Our Case Number: ACP-323066-25

Re: Gort Town Centre Public Realm Enhancement Project, Gort, Co. Galway
In the townlands of Gort, Co. Galway

RE: Gort Town Centre Public Realm Enhancement Project, Part 10 Application

2.4 Bus stops

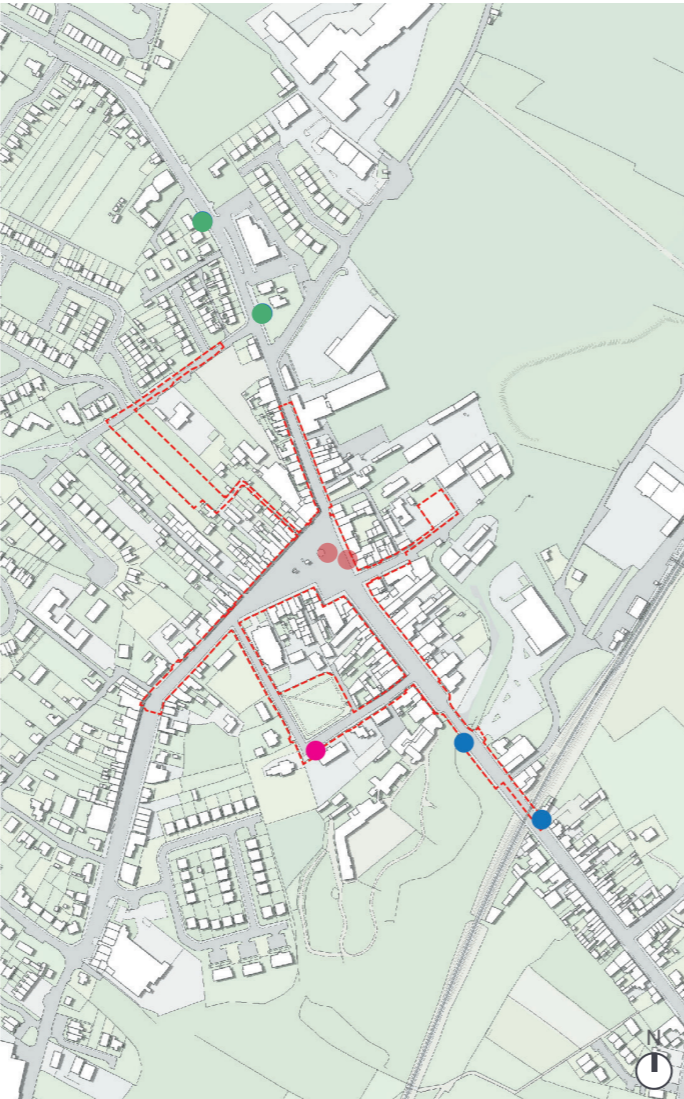
Drawing 3160-BDP-00-XX-DR-L-0001 indicates the proposed locations of the relocated bus stops. The proposed southbound stop is located to the south of the railway bridge, while the northbound stop is indicated as opposite the entrance to Aldi. These are roughly 250-350m from the current bus stop locations and are not located in the core town centre area.

It is the view of the NTA that the current bus stops in the town centre of Gort are well located, in a high profile, central location to facilitate high demand trips to/from town centre. It is the view of the NTA that this would disincentivise bus usage by increasing walking distance from residential areas and the town centre to the bus stops.

The NTA recommends that the proposed Part 10 scheme is not approved in its current form whereby bus stops are removed from the core town centre location, a key destination, which may have the effect of reducing the convenience and attractiveness of public transport usage in the town.
